Two storey side extension to existing detached house. Conversion of integral garage.
Old Sussex Seafield Road East Preston

Thank you for your internet representation made on 24th March 2019 which has been recorded as '**an objection**' with the comments as follows:

I am commenting on this application on behalf of the East Preston and Kingston Preservation Society.

Site Block Plan (1:500)

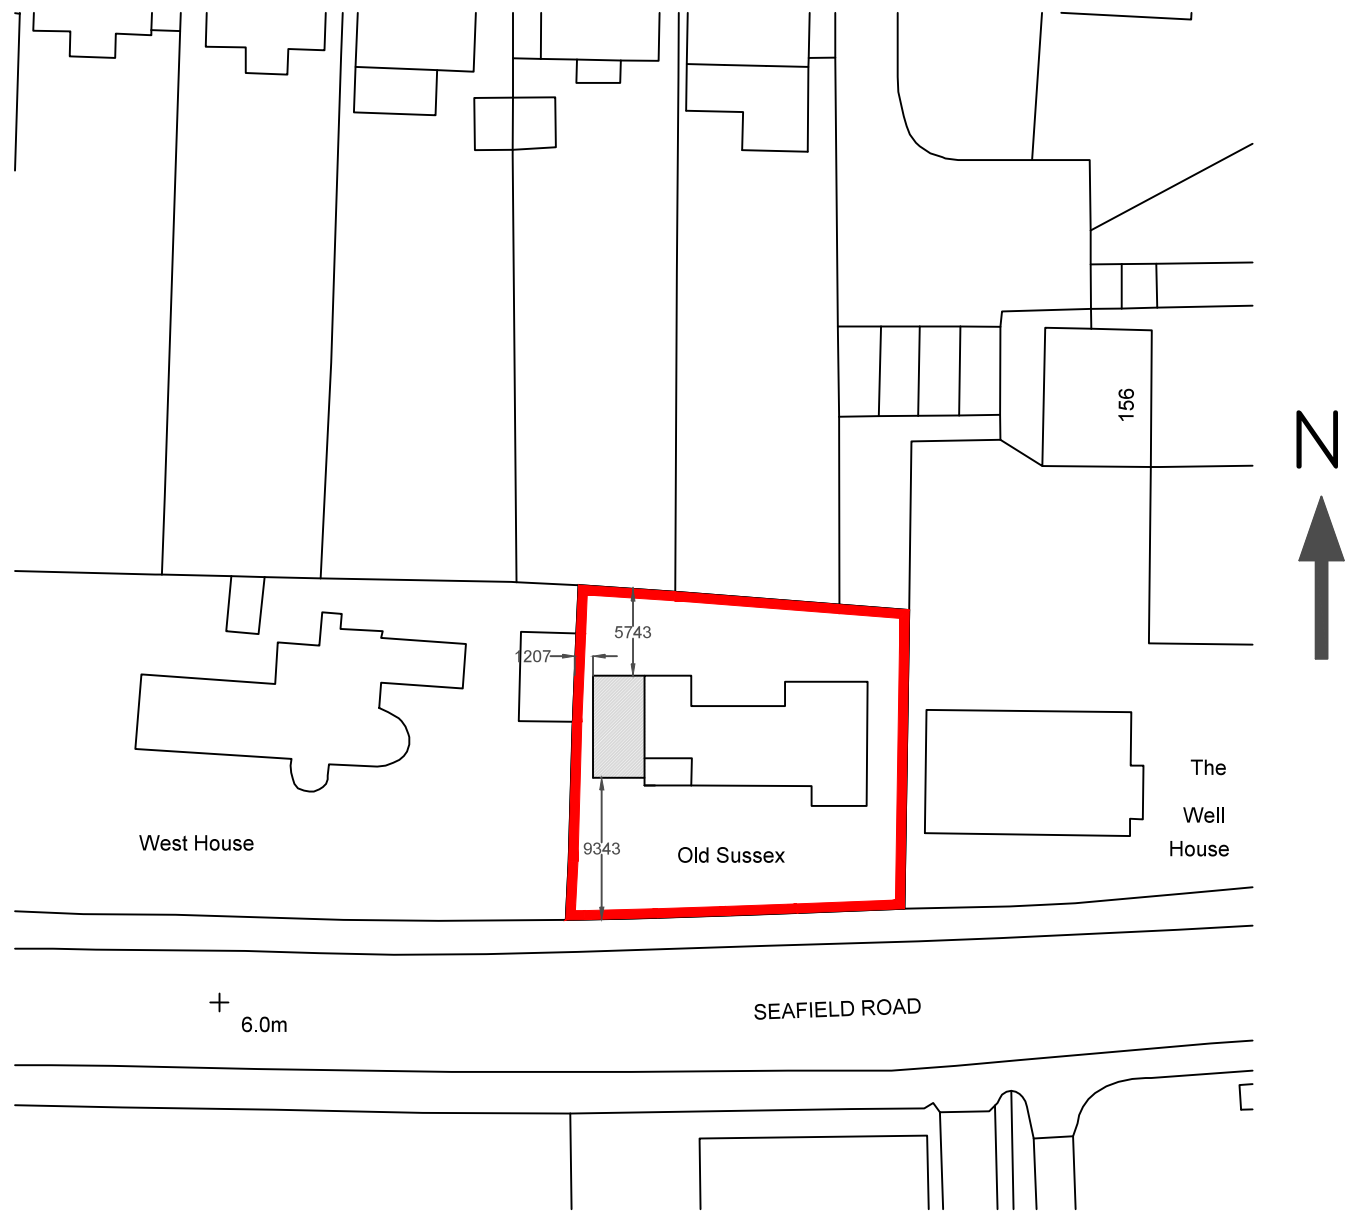
The proposed side extension is much deeper than the present house and its height has been restricted by leaving a large area of the roof flat. The character of the extension therefore differs significantly from that of the original house, and this difference in character will be very apparent at any viewpoint other than dead ahead. The difference in roof height, created by cutting off the top of the roof of the extension, would emphasise that the extension was not part of the original house.

These features would render the extension in breach of Policy D DM4 of the Arun Local Plan, because the extension would not be visually integrated with the existing building; and with Policy 1 of the East Preston Neighbourhood Plan, because the extension would not reflect the character and scale of surrounding buildings, and would not look as if it was part of the original design of the house.
